# CITY OF ALBUQUERQUE

**Re: Taco Bell/Retail Development-Snow Vista Blvd SW**  
**Draft Traffic Impact Study(L09D032)**  
**Engineer's Stamp January 15, 2025**  
Via email: [chuffine79@gmail.com](mailto:chuffine79@gmail.com)

The subject Traffic Impact Study (Study) draft received on February 14, 2025 , has been reviewed by the City of Albuquerque Planning Development Transportation Section and provides the following comments.

# C400

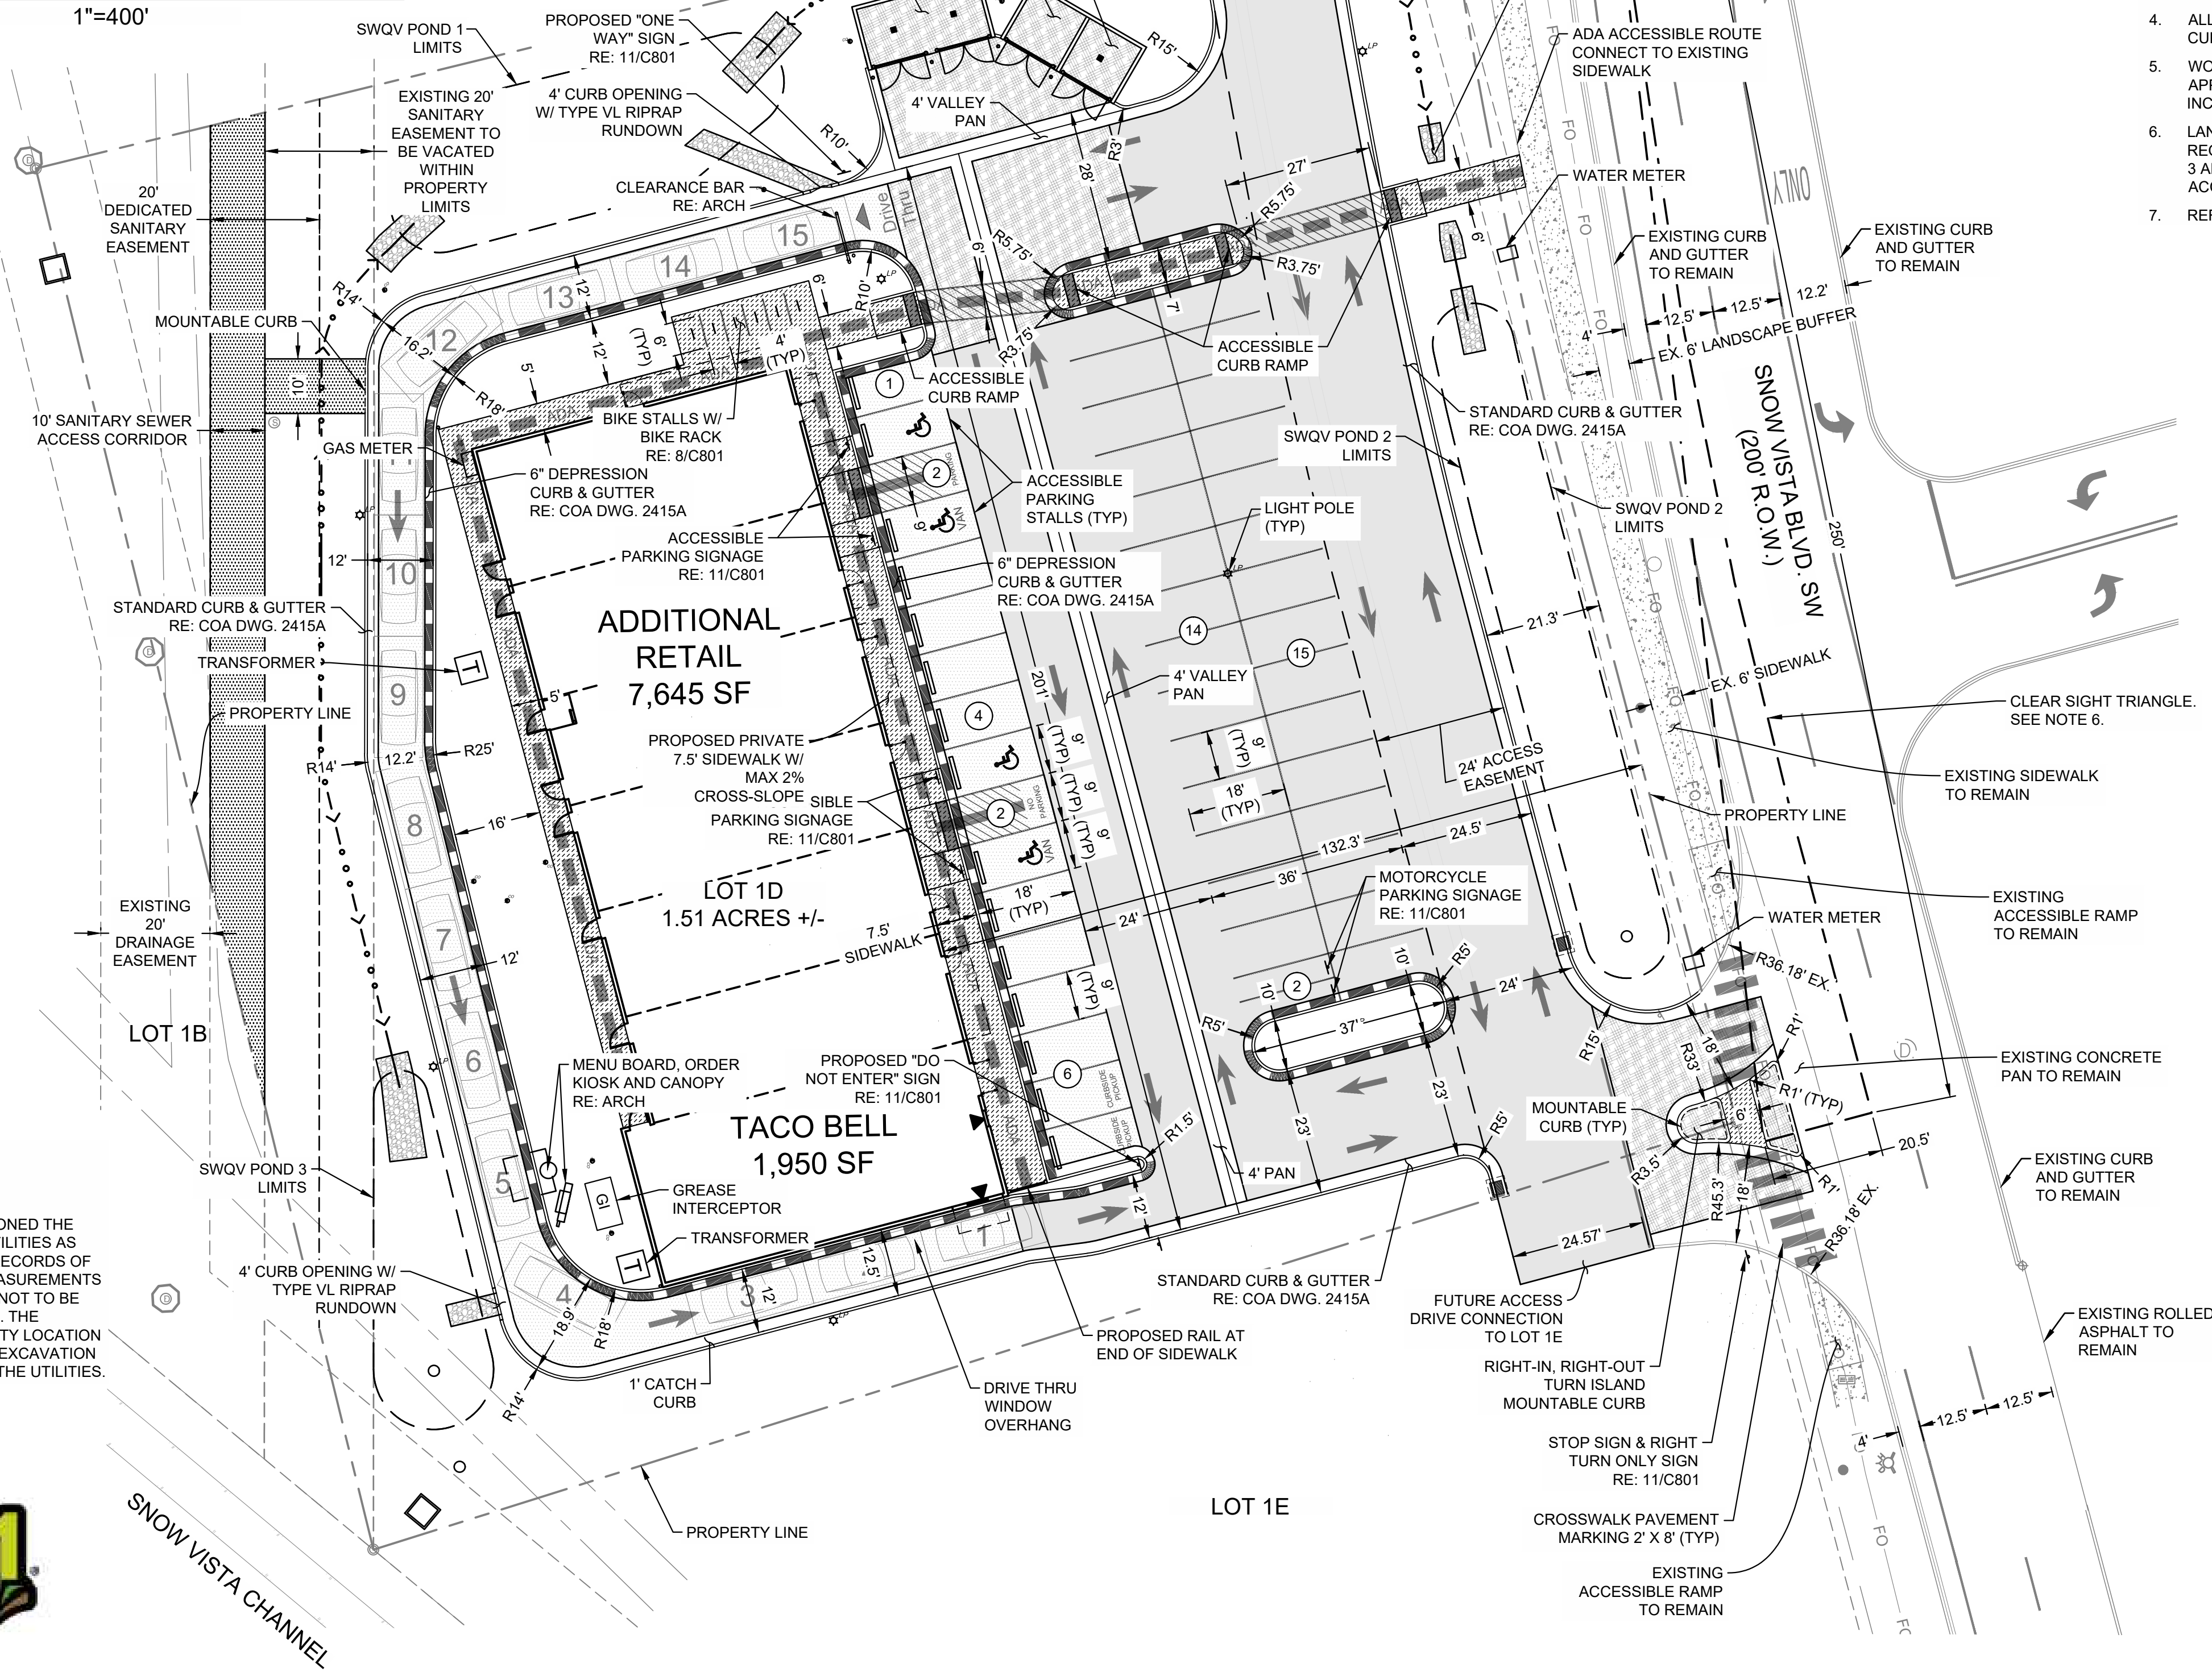
1. Assign trips to all site driveways (Access #3 was not included) .
2. Rather than constructing the Snow Vista Blvd SB right turn lane, it would be beneficial for the developer to construct a NB left-turn lane on Snow Vista Blvd at Access #3 to prevent traffic from backing up into the Snow Vista Blvd through-lane.
3. Provide an 11"x 17" minimum size site plan that is more legible than the current one.
4. As discussed at the scoping meeting, provide hardscape to enforce the right-in/right-out at Access #1. The northern beginning of the radius for Access 1 is approximately in the same location as the southern beginning of the curb return of the median opening. This is too easy to shortcut.

-The driveway appears to be approximately 30 feet wide. This is wide enough for a pedestrian refuge/porkchop.
